OXFORDSHIRE COUNTY COUNCIL'S RESPONSE TO CONSULTATION ON THE FOLLOWING DEVELOPMENT PROPOSAL

Application no: 14/01384/OUT

Proposal: Development comprising redevelopment to provide up to 2600 residential dwellings (Class C3), commercial floorspace (Class A1 - A5, B1 and B2), social and community facilities (Class D1), land to accommodate one energy centre, land to accommodate one new primary school (Up to 2FE) (Class D1) and land to accommodate the extension of the primary school permitted pursuant to application (reference 10/01780/HYBRID). Such development to include provision of strategic landscape, provision of new vehicular, cycle and pedestrian access routes, infrastructure, ancillary engineering and other operations

Location: Bicester Eco Town Exemplar Site Banbury Road B4100 Caversfield

**Figure 6.7: Vehicular Access Strategy**

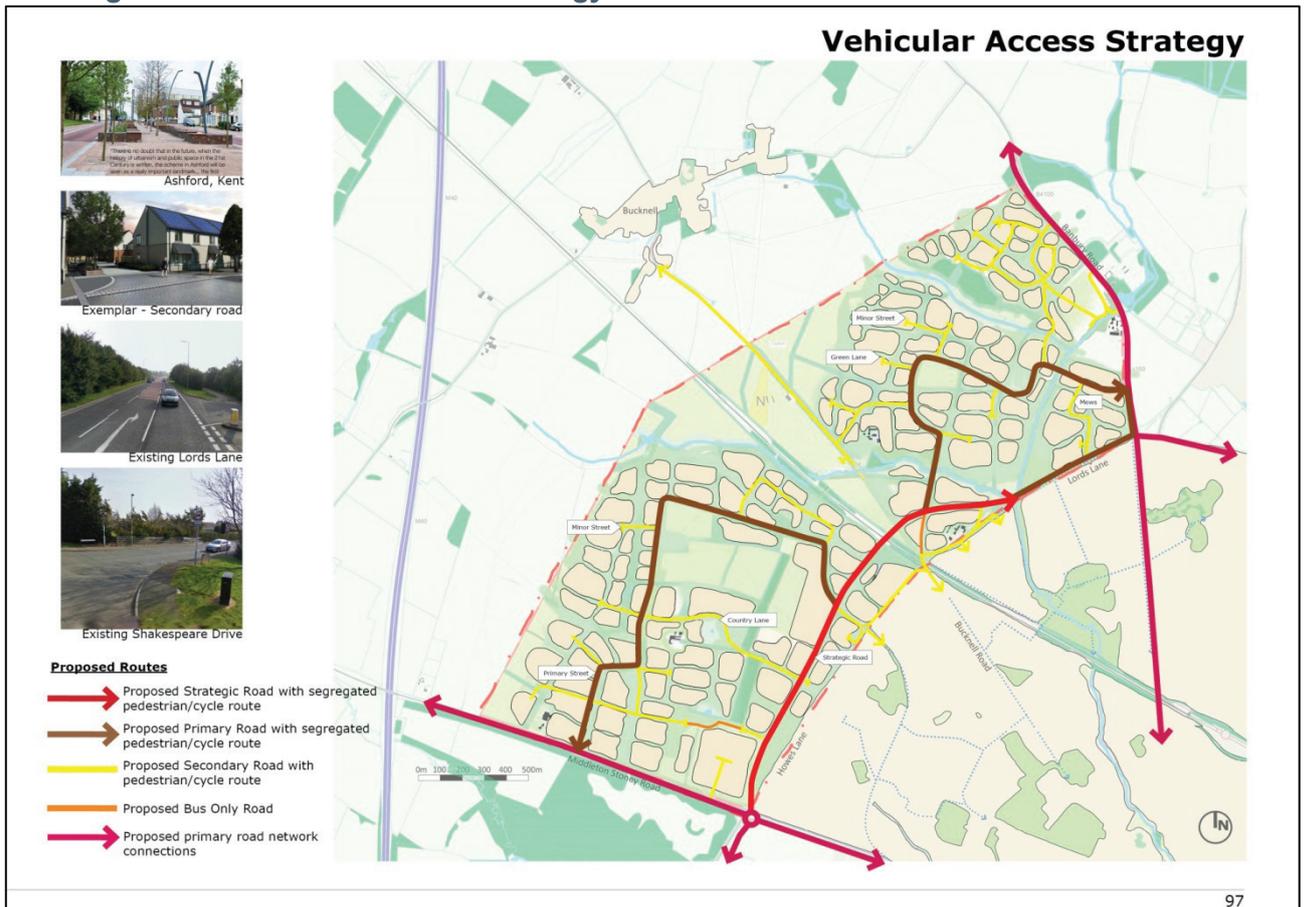
It is unclear from the transport submission where the specific locations of the vehicle access points to serve the application site are and how many of the 6 access points stated in the TA (page 63) are to be provided to serve this application proposal. **This needs to be confirmed.**
